Re: 330 Church St, Parramatta – MP10_0171 MOD 6

We write to express our objection to the modification. The modification proposes a further amplification of the development proposal (additional 6 storeys and additional 4,453sq m of floor space) without any resulting public benefit or compelling reason, and has failed to address key safety issues identified by the Planning Assessment Commission. We consider the current modification to be contrary to the intentions of the previous determinations by the Planning Assessment Commission.

01 PLAN - PODIUM LEVELS 1-3
1:100

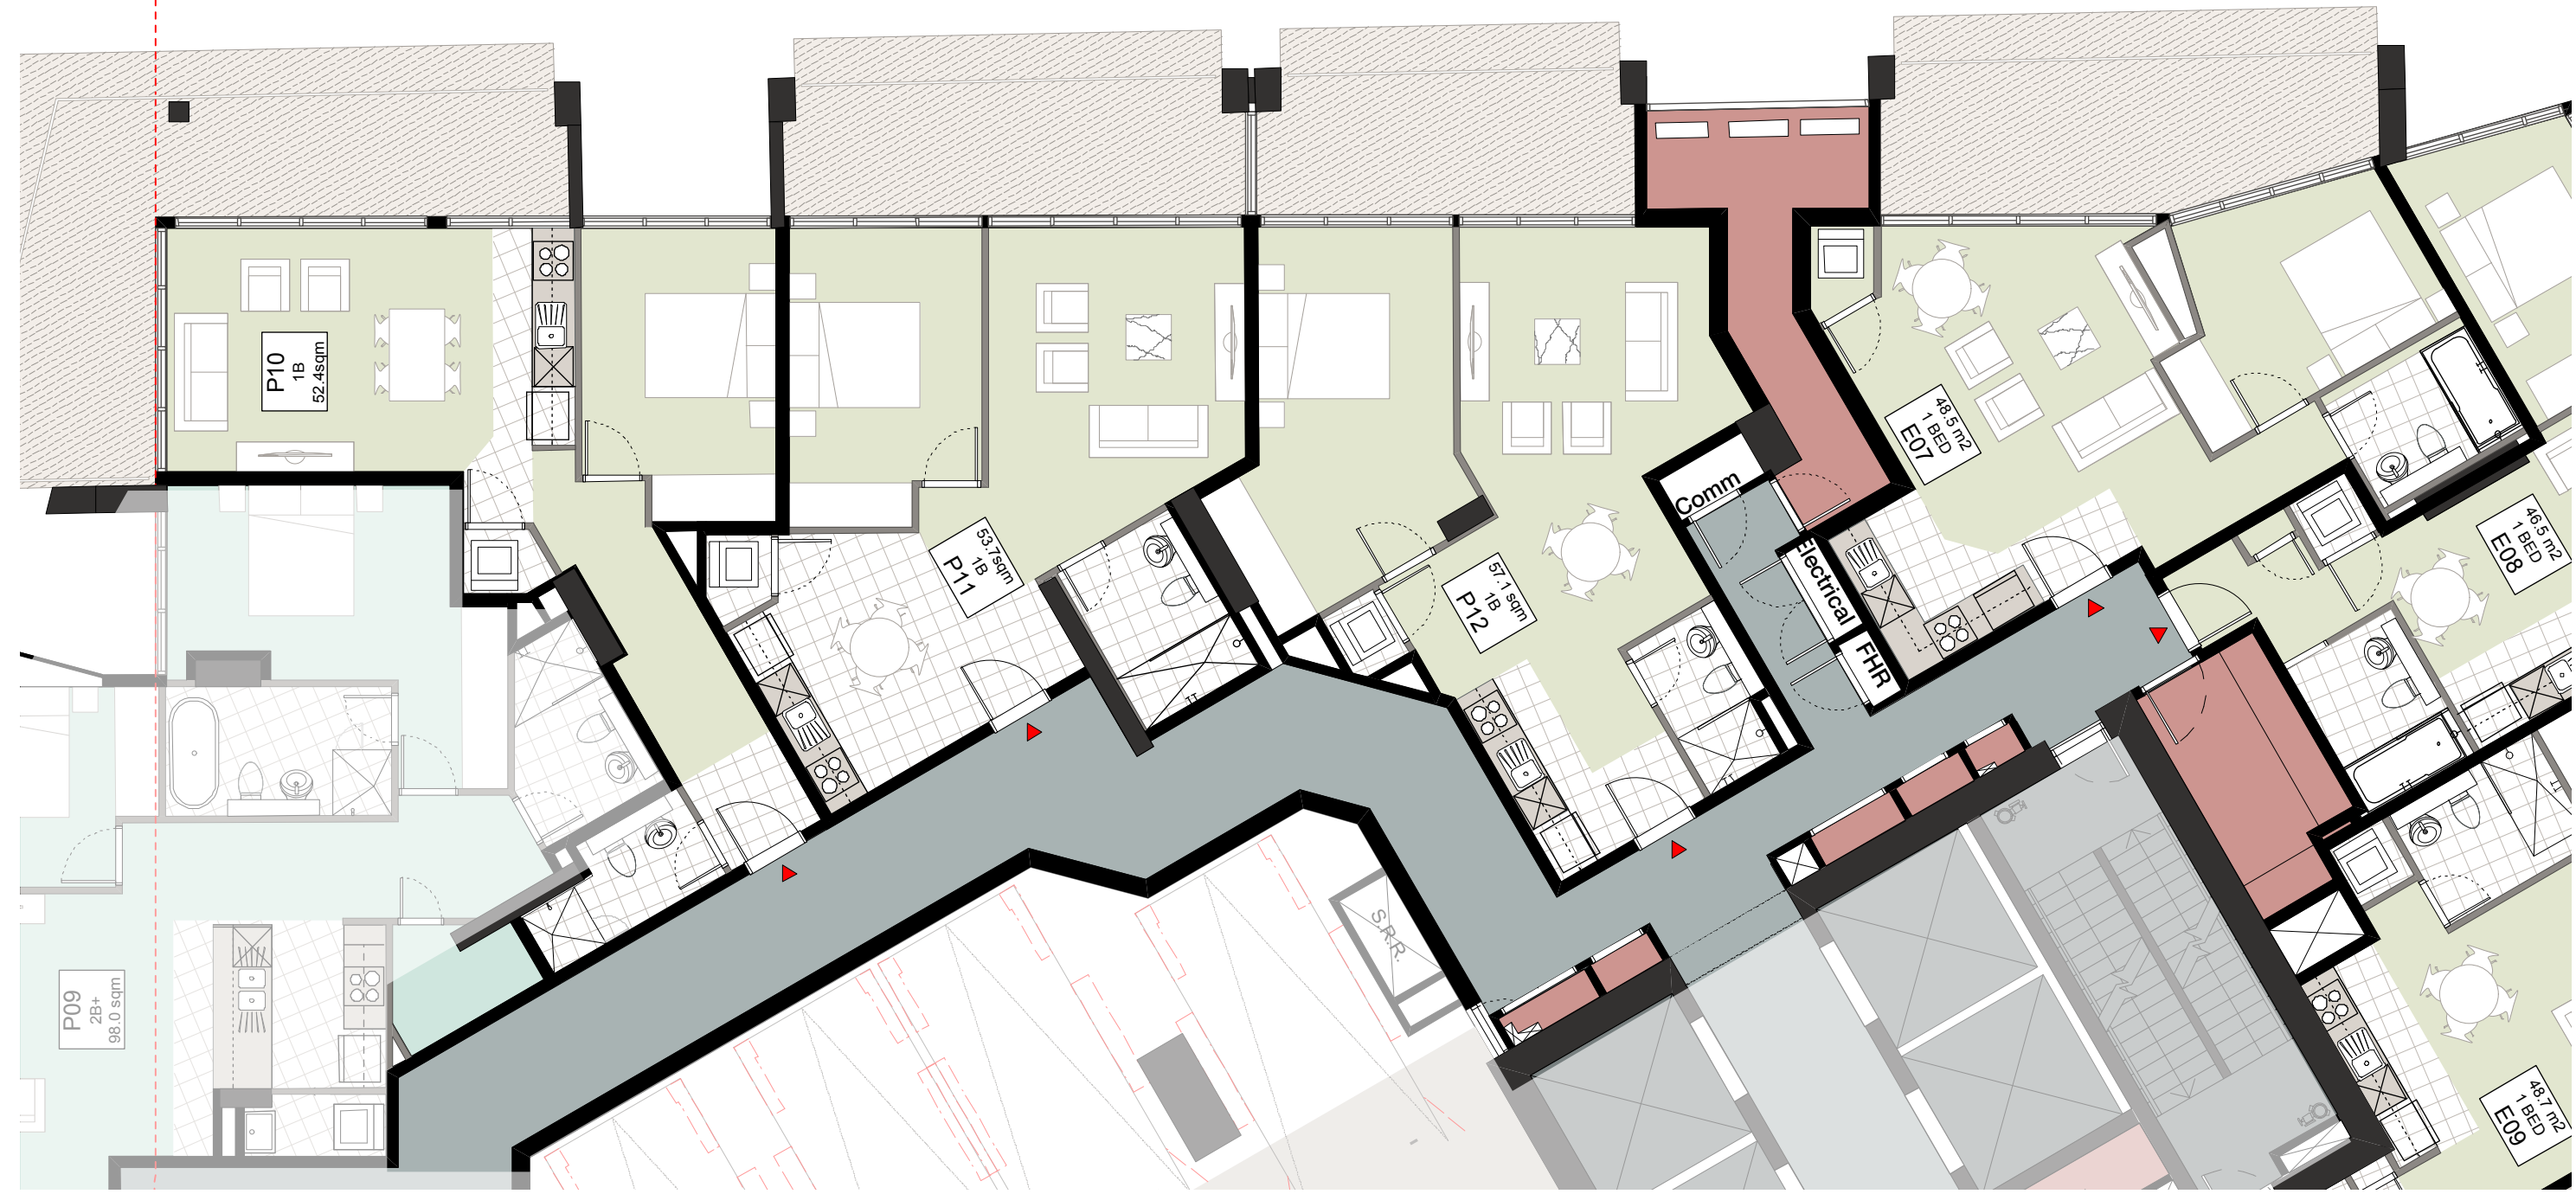
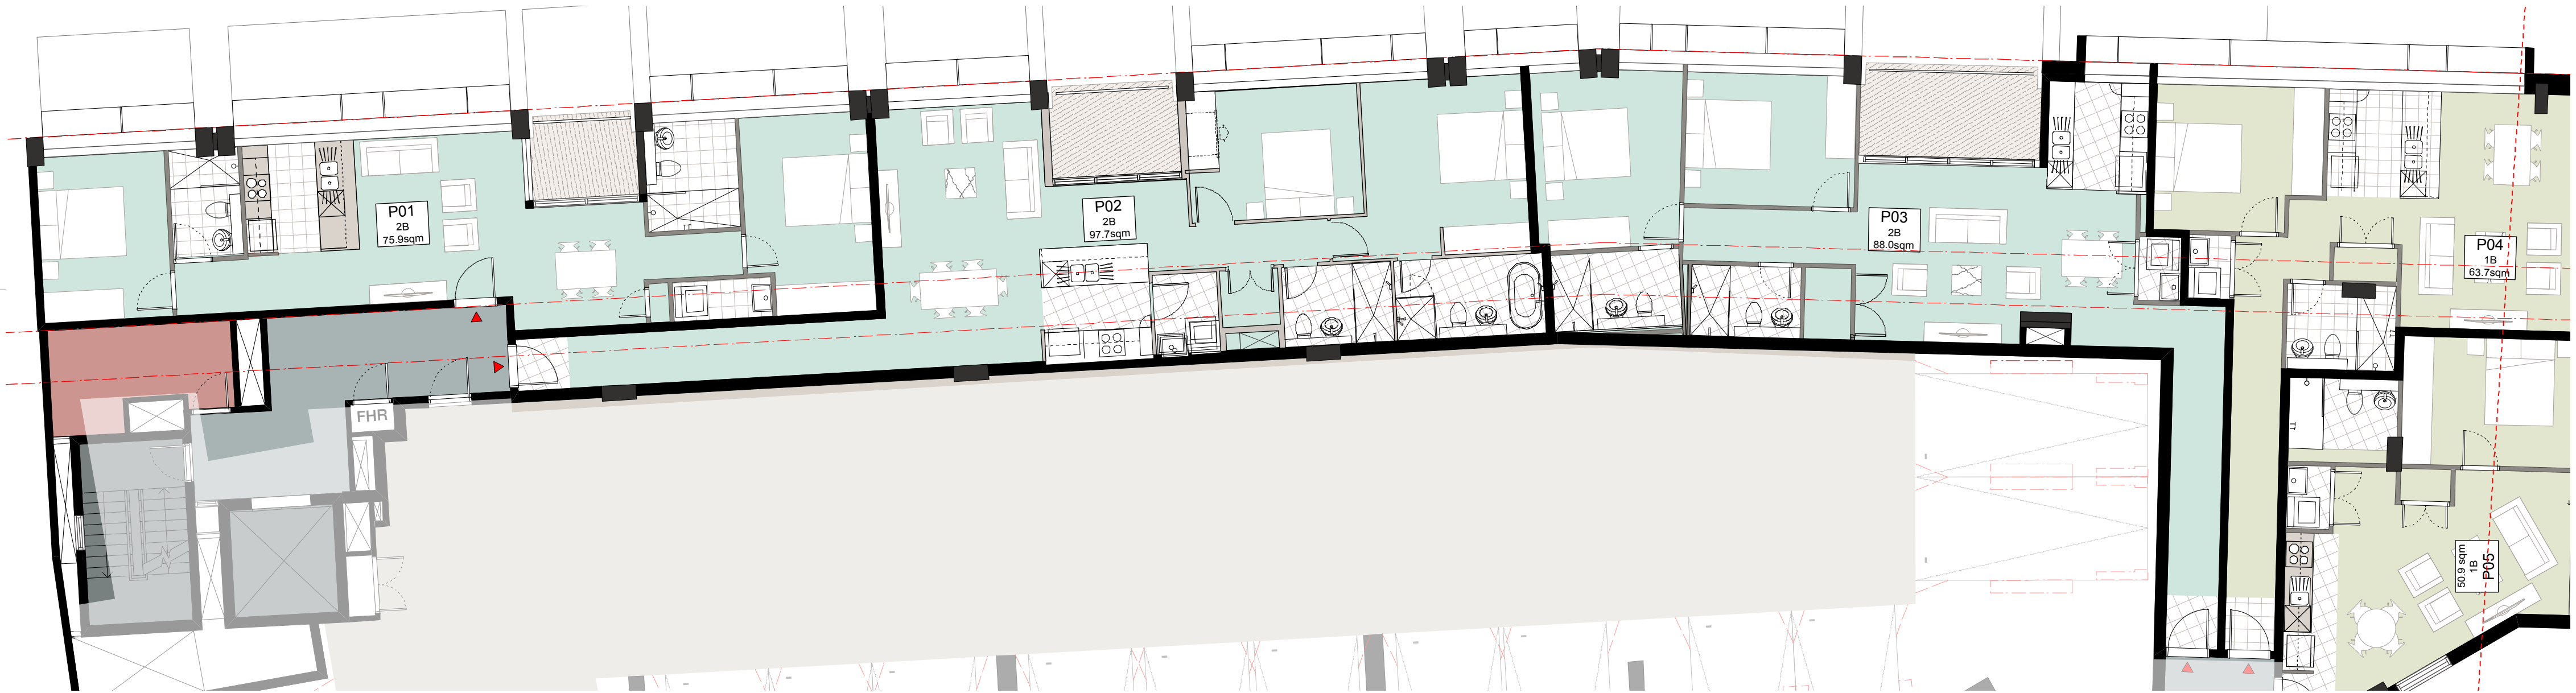
It is clear that the description significantly failed to capture the changes in relation to the rear access. As can be seen in the approved Mod 4 plan below, the amendments that immediately impact upon the safety of the laneway included –

- the relocation of the ‘down ramp’ in the basement to the west ensuring that numerous car movements now occur in closer proximity to the rear of the restaurant; and
- a reduction in the truck loading area and introduction of potential traffic conflict between loading vehicles and resident / visitor vehicles.

Notably, the opportunity to address condition B41 and consider the safety of pedestrian and vehicular movements in the laneway at the southern boundary of the site was not pursued by the applicant, nor insisted upon in the assessment by the Department of Planning and Environment. The further reduction in safety and further is a significant oversight. It is our view that the intentions of the PAC in preparing condition B41 during its assessment of Mod 3 have been overlooked or ignored in the subsequent assessment of Mod 4. It is our view that any amplification of the proposal in terms of floor space, height, traffic movements, and purpose of accessing the site gives rise to the need to once again carefully consider the safety of pedestrians and vehicles in the laneway at the rear of the site.

- a) that the wall required in Modification 3 be reinstated, to its full length, to provide improved safety during construction and at the time of completion;
- b) that the current pedestrian and traffic conflict arising from the construction of the site be urgently resolved;
- c) the pedestrian and traffic conflict at the rear laneway is resolved (consistent with the intent of condition B41);
- d) loading facilities for the El Phoenician restaurant are provided; and
- e) the significant uplift in height and floor space be justified on the basis of a new public benefit provided by the proponent.
